From: Terry Seymour
Sent: 02 September 2021 14:25
To: 'Laura Gibbons' [REDACTED]
Subject: RE: Sefter Road

Laura Gibbons
Engineer, Adur & Worthing Councils

Subject: Re: Seftor Road

Drawing Title: Surface Water Drainage Strategy Layout

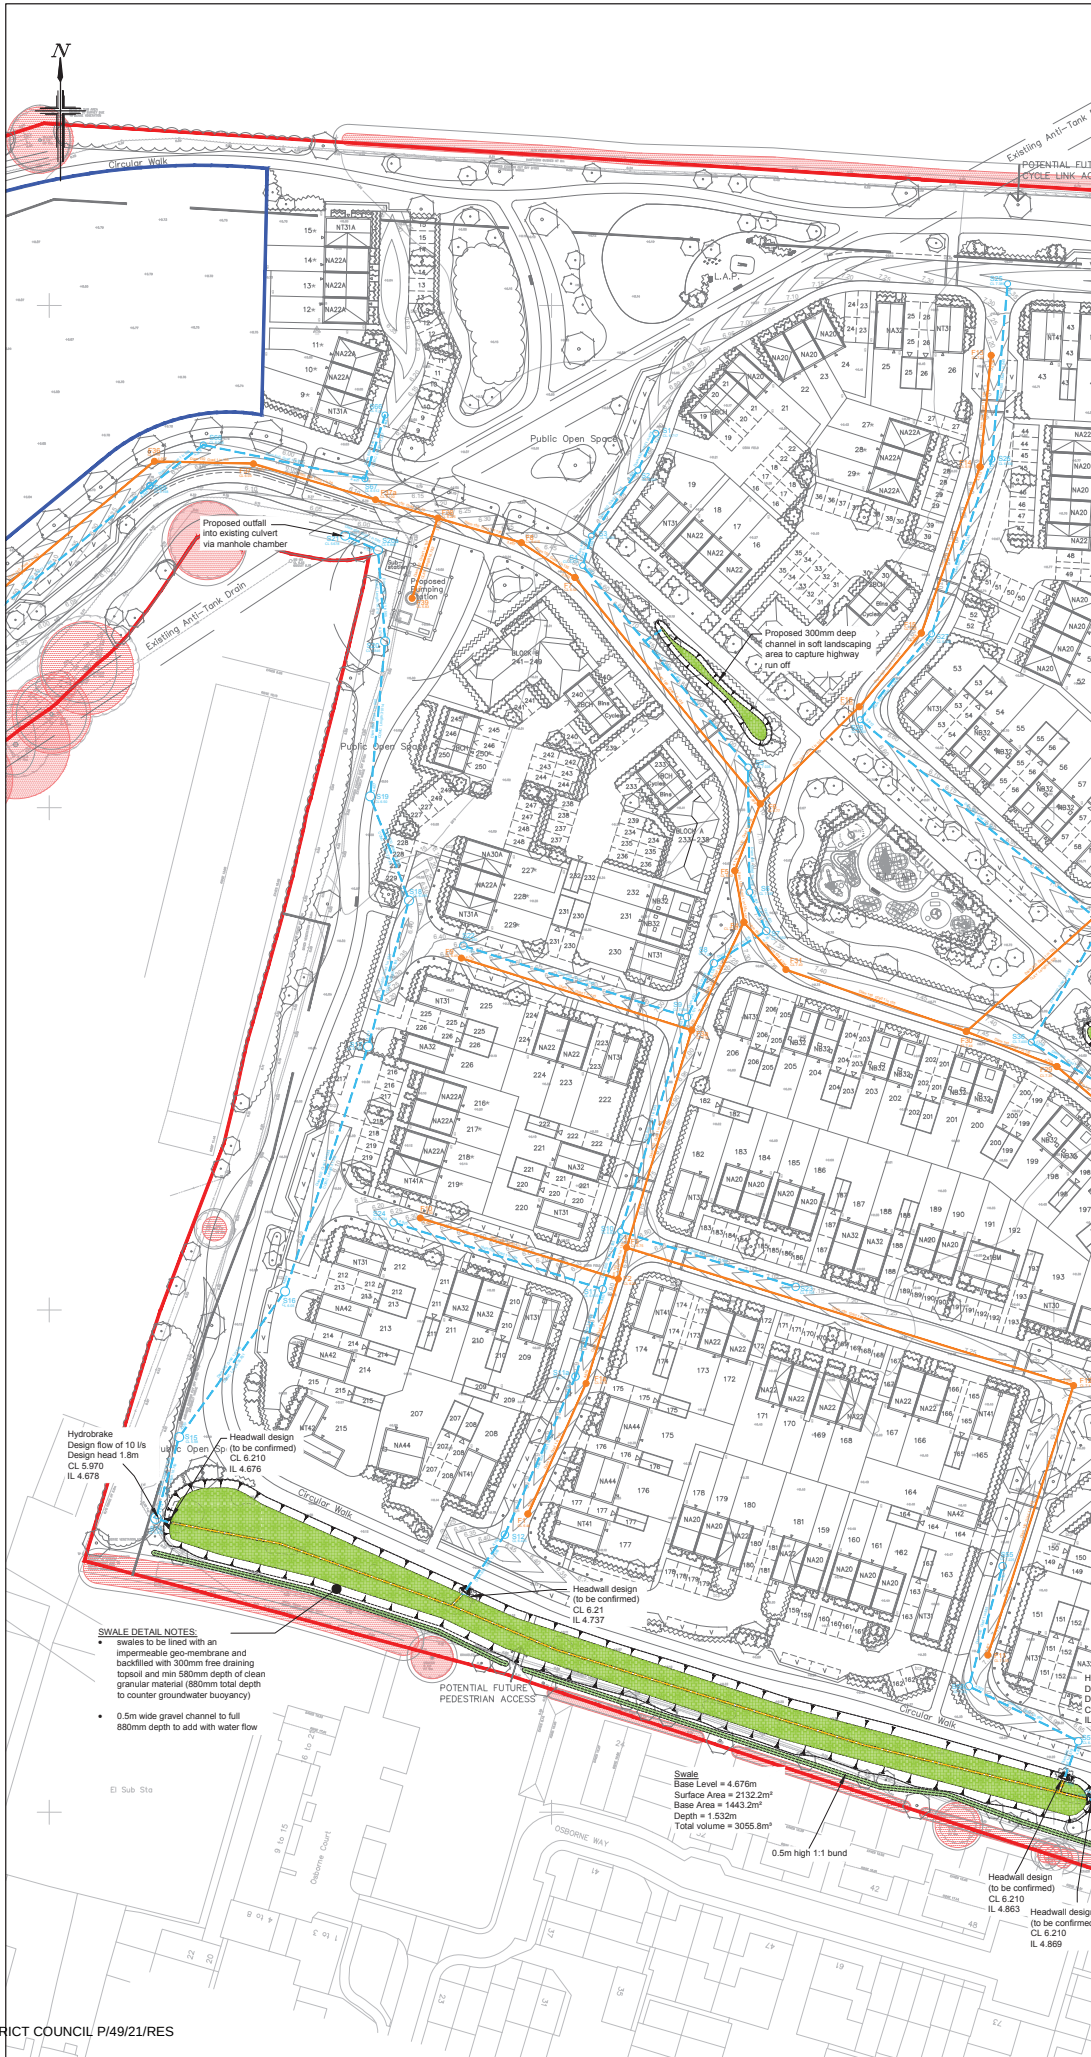
Thanks for this. I've been having a look over the proposals and there are a lot of trees within very close proximity of the basins. For example:

Our stance is that there must not be conflict between root potential areas and drainage features (both pipelines and storage areas) when there is a need to line features. When reviewing proposals we either work with Southern Water's tree planting guide (attached) or specific root potential areas provided on plan by landscaping consultants (preferred due to the variety of species usually specified).

I need some rough/simple drawings of the basins to verify that the sizes and levels are achievable. I will be doing Arun work tomorrow pm should you be able to get anything over to me.

I will relay this back to TW and the Landscape Architect and see if they can move these trees back and clear to avoid need for the root barrier.

Thanks for your time earlier, please see attached drainage strategy drawings with the future access strip drawn in magenta. These are all 3m wide with exception on two instances in the south east where these have been reduced to 2m where passing between two of the basin but you can still get access round the majority of these basins.

Regarding landscape drawings, I will get these over to you tomorrow, I do take your point on the concern of the trees going through the liner and pretty sure we don't have any proposed within the confines of the liner but will send these over for confirmation in the morning.
